From: [REDACTED]
Sent: 04 February 2019 09:10
To: Planning
Subject: R/7/19/CLP 9 Hawke Close Rustington

I wish to raise objections to the above planning application regarding the east elevation of the property.

18109-501

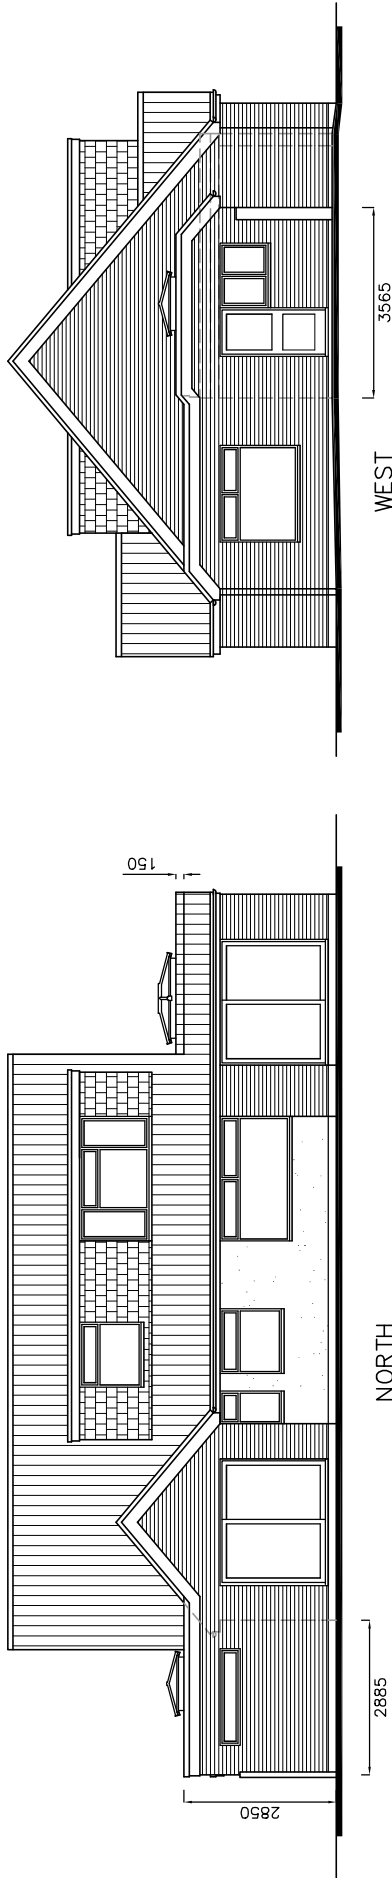
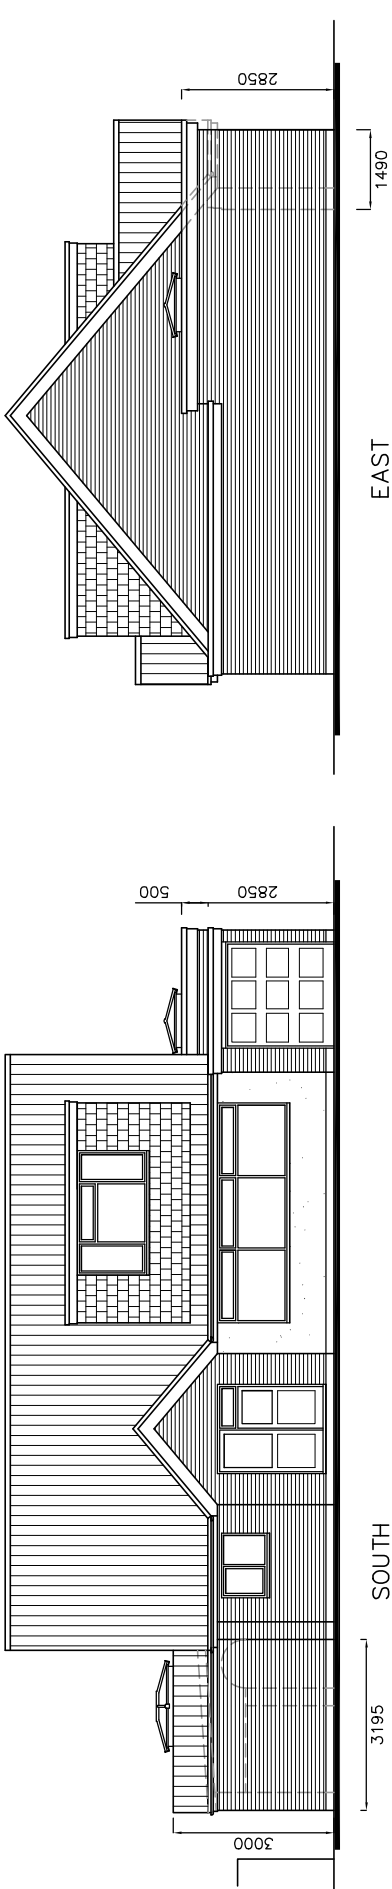
I note the planning application wishes to raise the roof of the rear of the existing garage to a height of 9ft 4 inches at the rear and extend the building another 5 ft approximately. Given that the garage and the old extension are built on the boundary line of the property and also raising the roof to 9ft 4 inches would have the impact of making us feel really enclosed and have a detrimental affect in the summer months of blocking out the sun on my patio. Given that a boundary fence may only be permissible to a height of six feet, it seems illogical to allow a boundary wall extension to a height of 9ft 4 inches.

Surely to build an extension still further on the building line will contravene the building regulations act. The extension wall should be built in from the boundary line.

I would suggest that to allow further extensions to the property on the east elevation without further examination by the planning authority would not be right.
